TBT ENGINEERING CONSULTING GROUP

TBTE Ref No: 26-0120

Subject: City File Number: D02-02-24-0029
Update to Geotechnical Investigation
Concept Plan (April 2026)
2095 Dilworth Road
Ottawa, Ontario

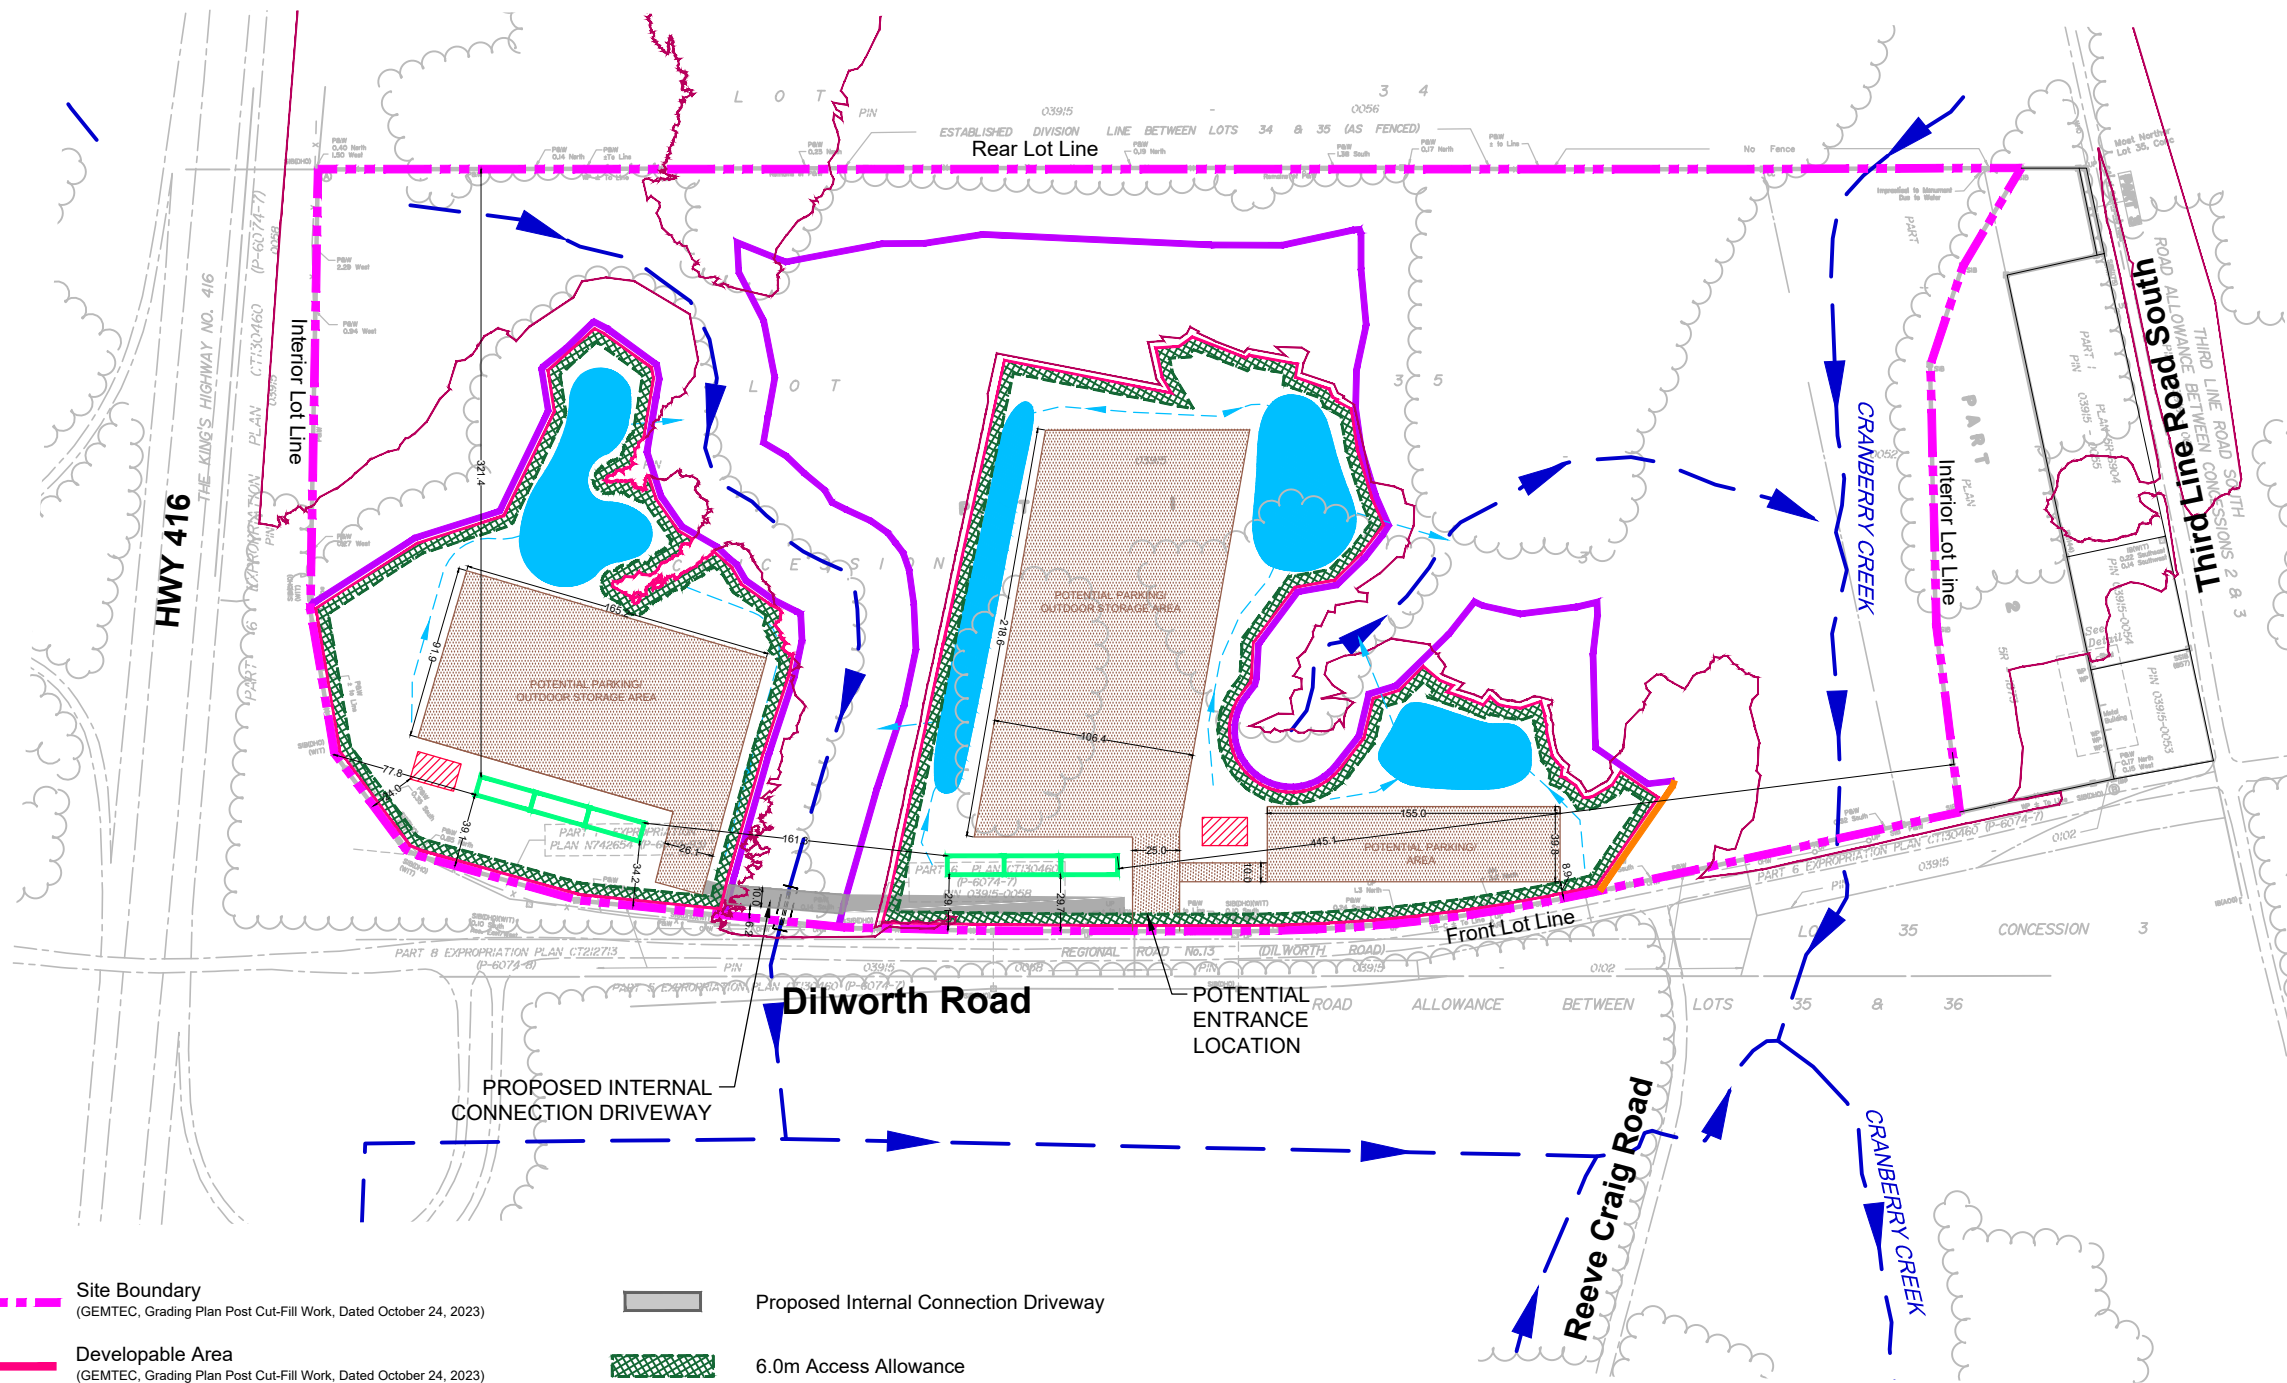
The current potential concept plan has only two buildings, located along the south limit of the Site. The proposed buildings are located in the vicinity of MW21-06 and BH21-05. No unweathered clays were encountered in these locations.

The current potential concept plan has only two buildings, located along the south limit of the Site. The buildings are intended to be single-storey slab-on-grade structures with no basement level. Buildings with no basement levels and a floor slab set at least 0.3 m above the exterior grade generally do not require perimeter drainage.
